From: Elliott, Stanice
Sent: Thursday, January 12, 2017 3:00 PM
To: 'David Soule'
Subject: RE: 6405 Picardia
Attachments: IMG_2098.JPG

Based upon the information provided in your submittal received 1-12-2017, the above referenced plan cannot be approved for PERM CO until the following comments are addressed:

Project Title: NUCE RESIDENCE **Building Permit #:** _____ **City Drainage #:** _____
DRB#: _____ **EPC#:** _____ **Work Order#:** _____
Legal Description: lot 30 block 8 volcano cliffs UNIT 22
City Address: 6405 PICARDIA PLACE NW

ENGINEER'S SEAL  5/18/16 DAVID SOULE P.E. #14522	6405 PICARDIA NUCE RESIDENCE GRADING AND DRAINAGE PLAN  <i>Rio Grande Engineering</i> 1606 CENTRAL AVENUE SE SUITE 201 ALBUQUERQUE, NM 87106 (505) 872-0999	DRAWN BY WCVJ
		DATE 5-19-16 21616-LAYOUT-5-18-16 SHEET # — JOB # 21616

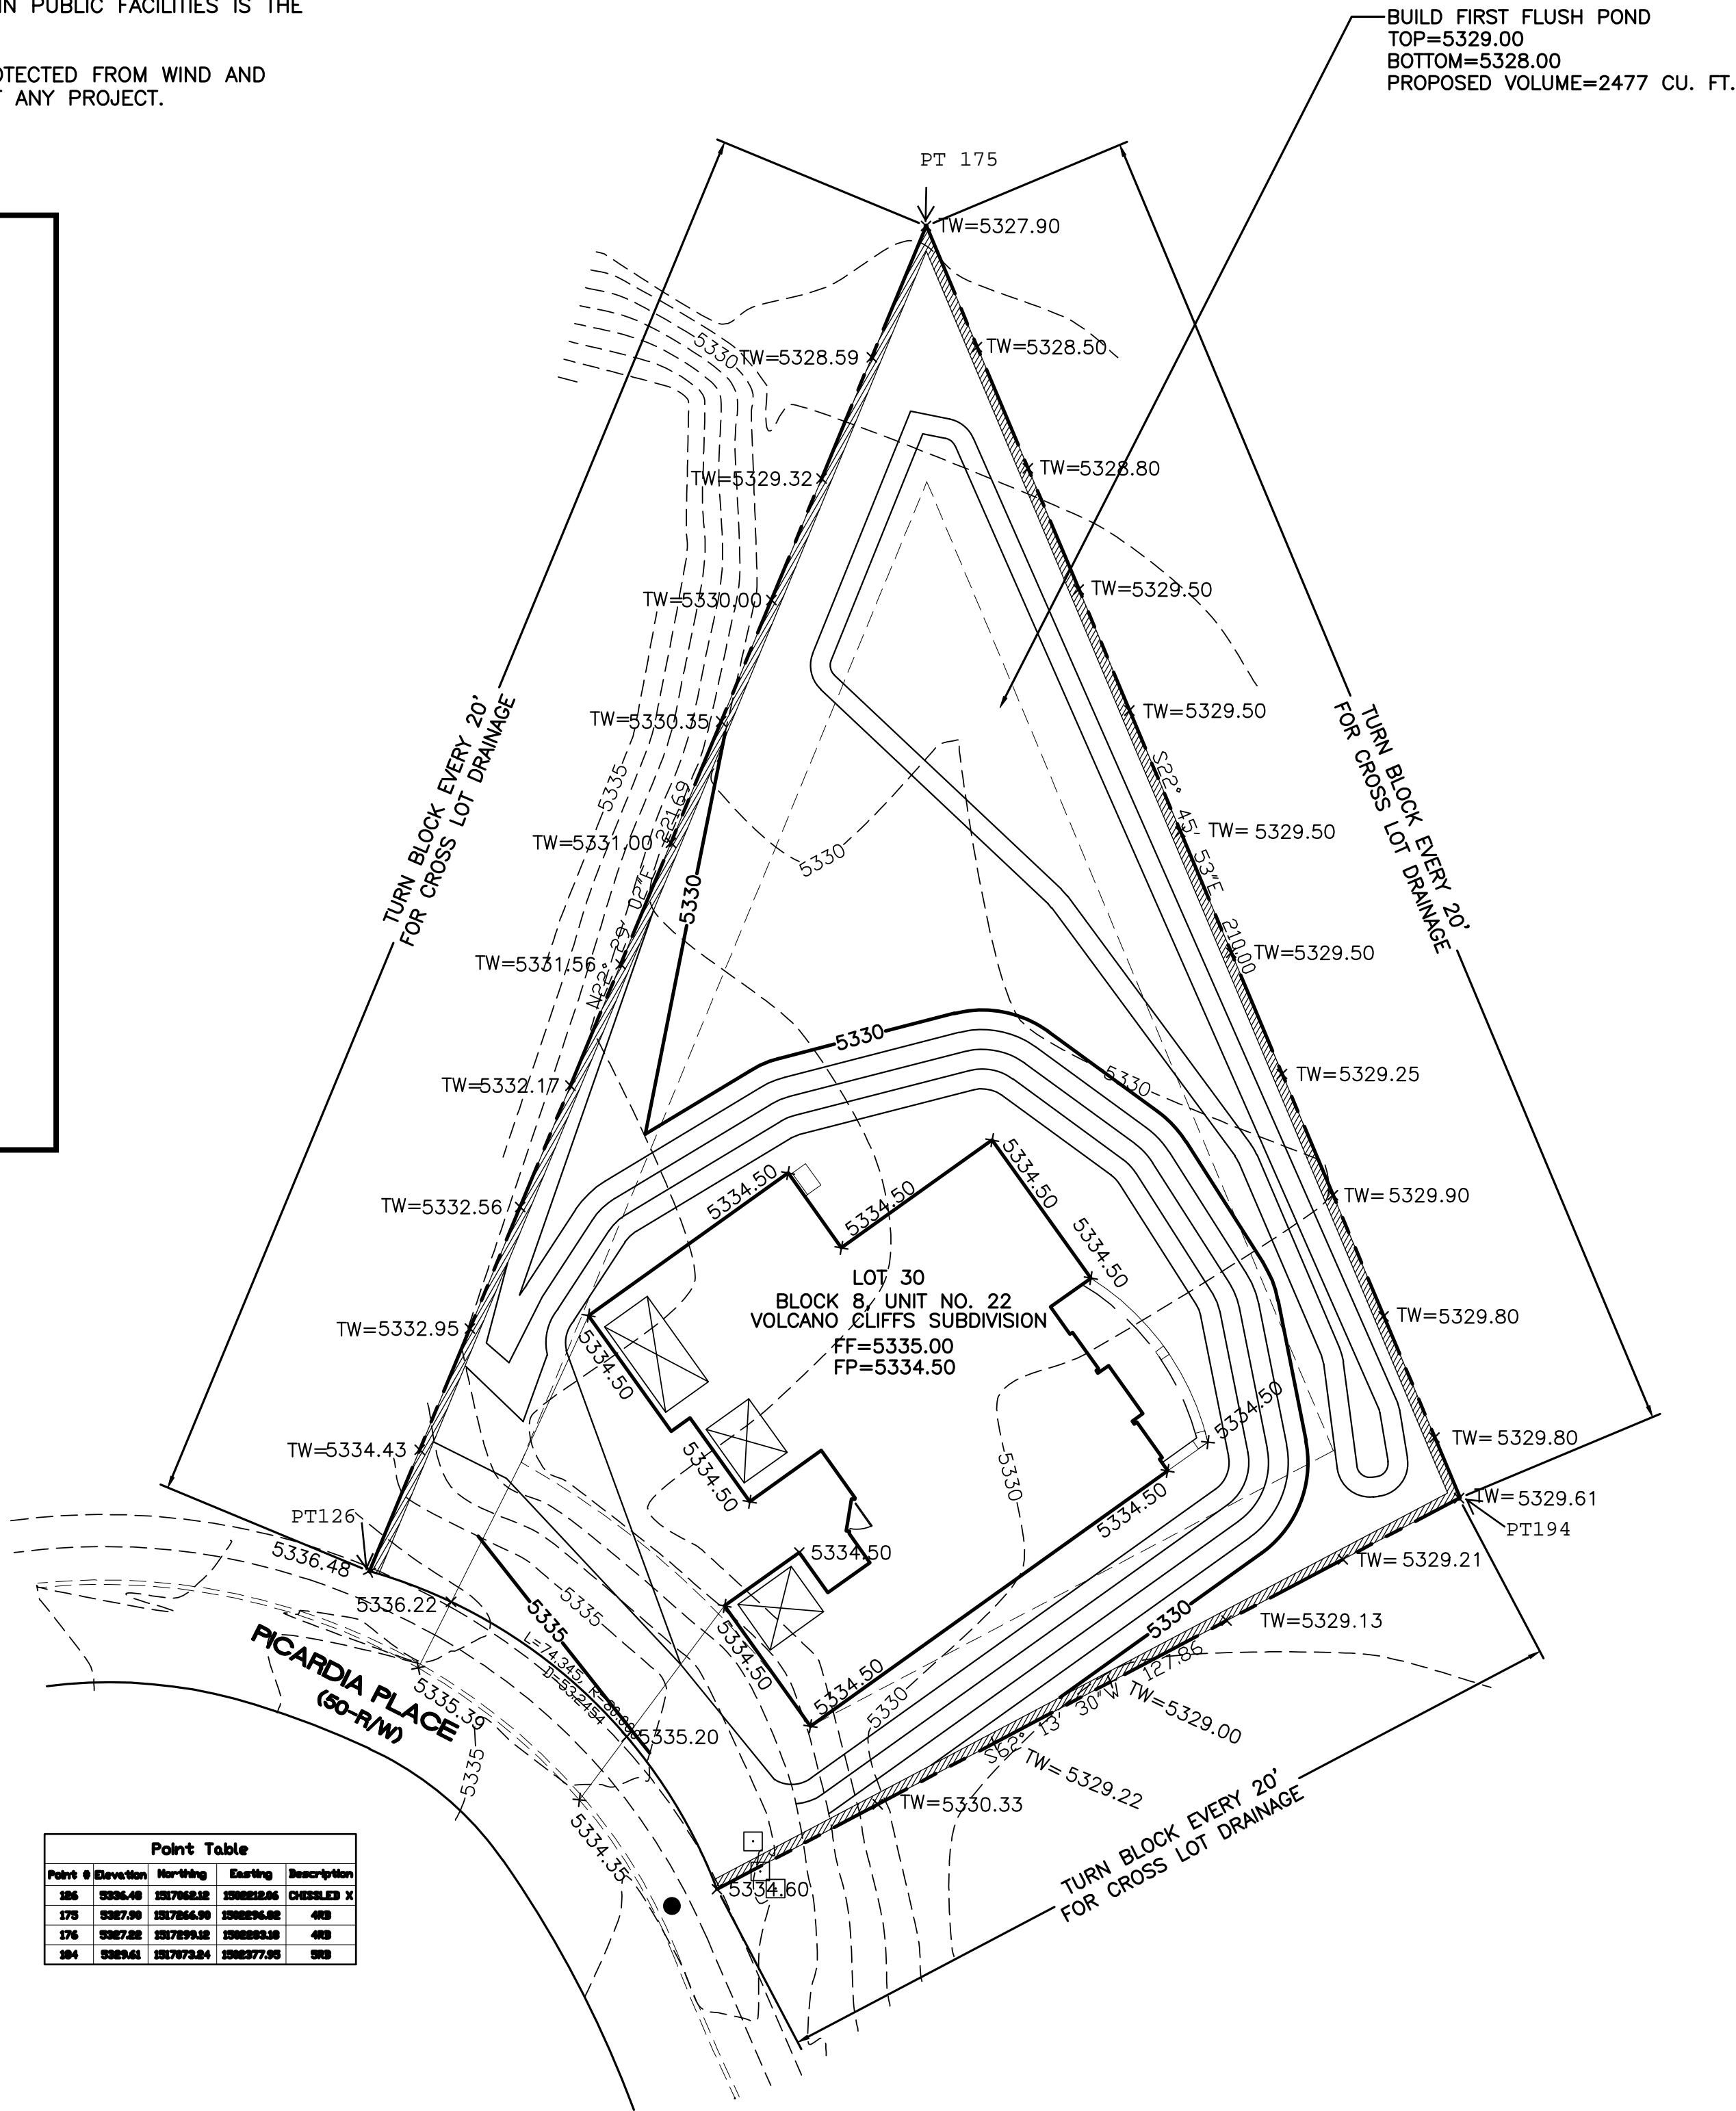
- The as-built points are difficult to read on the drawing.
- It appears dirt has been pushed on to another neighbors lot.
- The swale leading to the pond does appear to be present.
- The stake in the backyard is marked as corner of lot. Location does not appear to be a corner.

- The grades on site do not match grades on the approved grading and drainage plan
- Provide as-built grades
- Ensure that the grades match the approved SAD 228 Master Drainage Plan.
